# Rezoning Transportation Analysis

Petition Number: 2024-029

General Location Identifier: 02506206

Date	Description
04-24-24	First Review (IW)
05-22-24	Second Review (IW)
07-01-24	Third Review ZC (IW)

TECHNICAL DATA SHEET

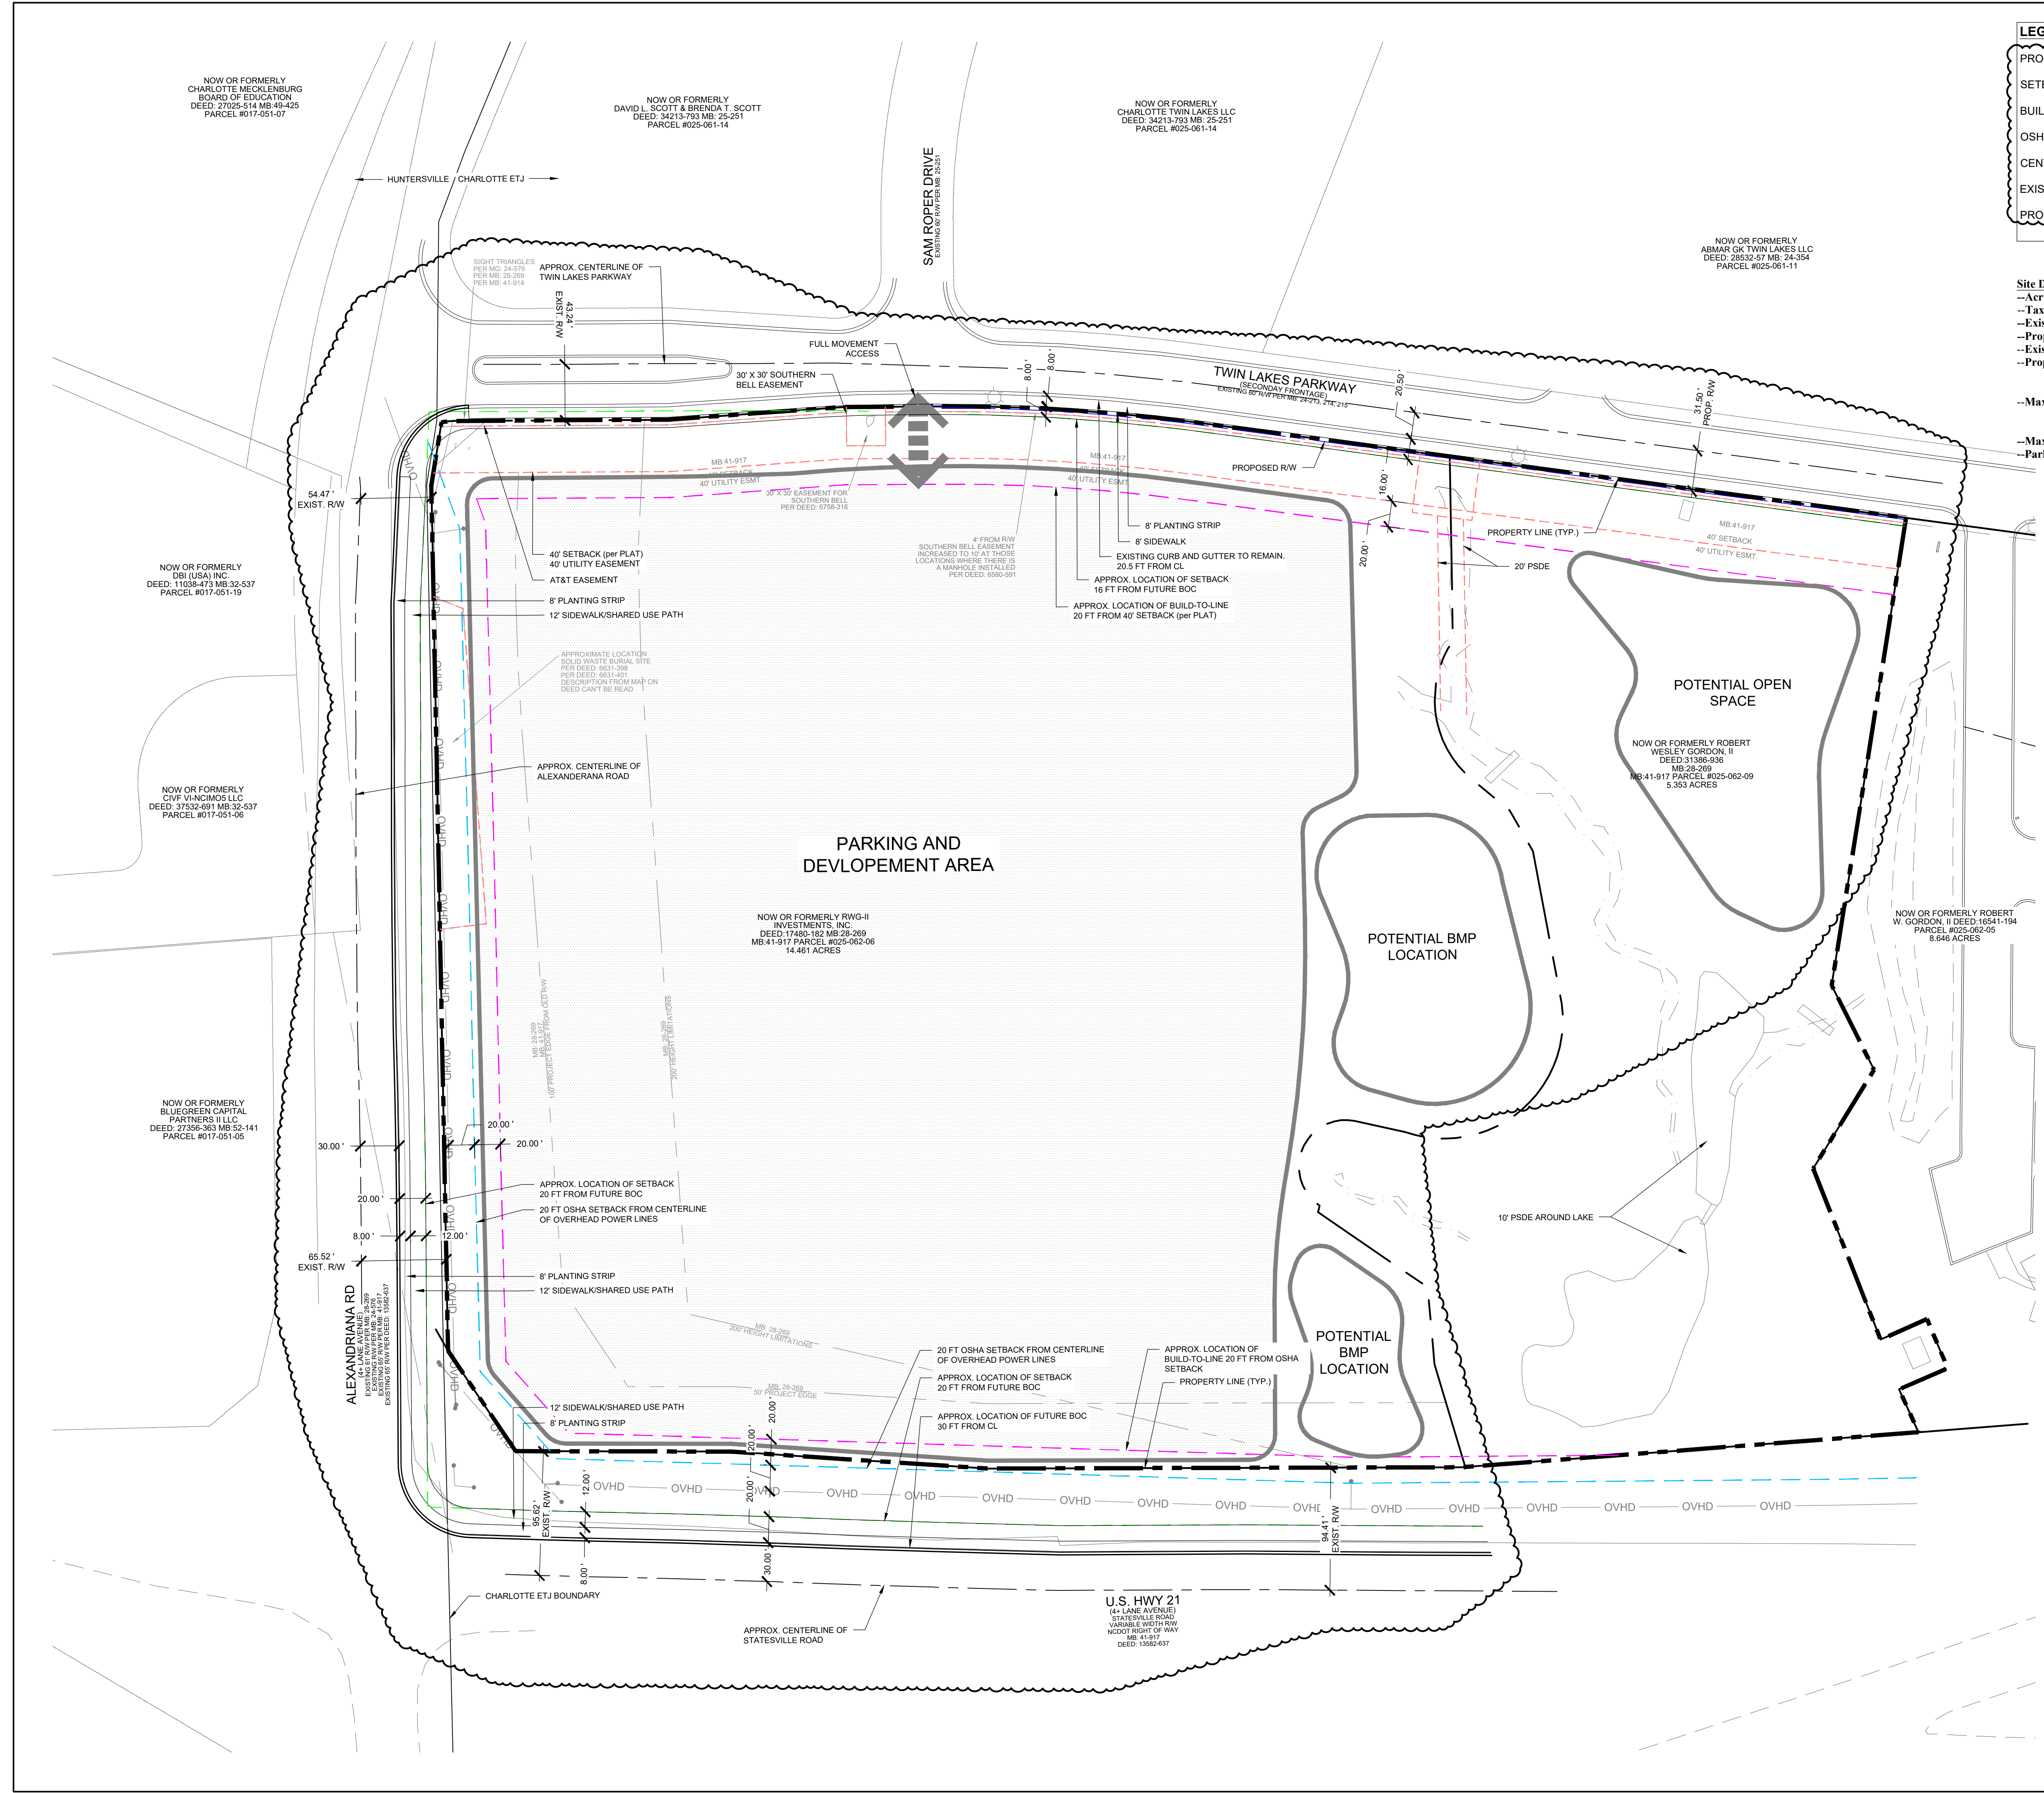
#### 1. ~~Curblines:~~

a. ~~**Alexandriana Road:** Location of future back of curb and gutter to be constructed 30' from centerline.~~

b. ~~**Statesville Road:** Location of future back of curb and gutter to be constructed 30' from centerline.~~

c. ~~**Twin Lakes Pkwy:** Location of future back of curb and gutter to be 17.5' from centerline.~~

~~Label and dimension the curb and gutter from the centerline for each road on the site plan.~~

~~**Clarifying Comment:** Site plan shows dimensions but still needs to label the centerline to curb dimension along Alexandriana Rd as "Centerline to future curb location"~~

- ~~3. Revise site plan and conditional note(s) to commit to dedicate 50' of right-of-way from the Alexandria road centerline. The site plan shall label and dimension the right-of-way from the road centerline.~~
- ~~4. Revise site plan and conditional note(s) to commit to dedicate 50' of right-of-way from the Statesville road centerline. The site plan shall label and dimension the right-of-way from the road centerline.~~

- ~~5. Revise site plan and conditional note(s) to commit to dedicate 31.5' of right-of-way from the Twin Lakes Pkwy road centerline. The site plan shall label and dimension the right-of-way from the road centerline.~~

- ~~6. Revise site plan and conditional note(s) to commit to construct bicycle facilities on Alexandria Road by installing a 12' multi-use path behind the 8' Planting Strip in accordance with the council-adopted Charlotte Streets Map. Multi-use paths maintained by the City shall meet ADA/PROWAG requirements.~~

- ~~7. Revise site plan and conditional note(s) to commit to construct bicycle facilities on Statesville Road by installing a 12' multi-use path behind the 8' Planting Strip in accordance with the council-adopted Charlotte Streets Map. Multi-use paths maintained by the City shall meet ADA/PROWAG requirements.~~

- ~~9. NCDOT REQUIREMENT: Revise site plan and conditional note(s) to commit to removing access from Alexanderana road. NCDOT is only allowing access for this site to come off of Twin Lakes Pkwy.~~

- ~~10. Revise site plan and conditional note(s) to commit to updating Transportation Note 3H to delete the fee-in-lieu option as ped program would be unable to spend funds and construct in the ETJ.~~
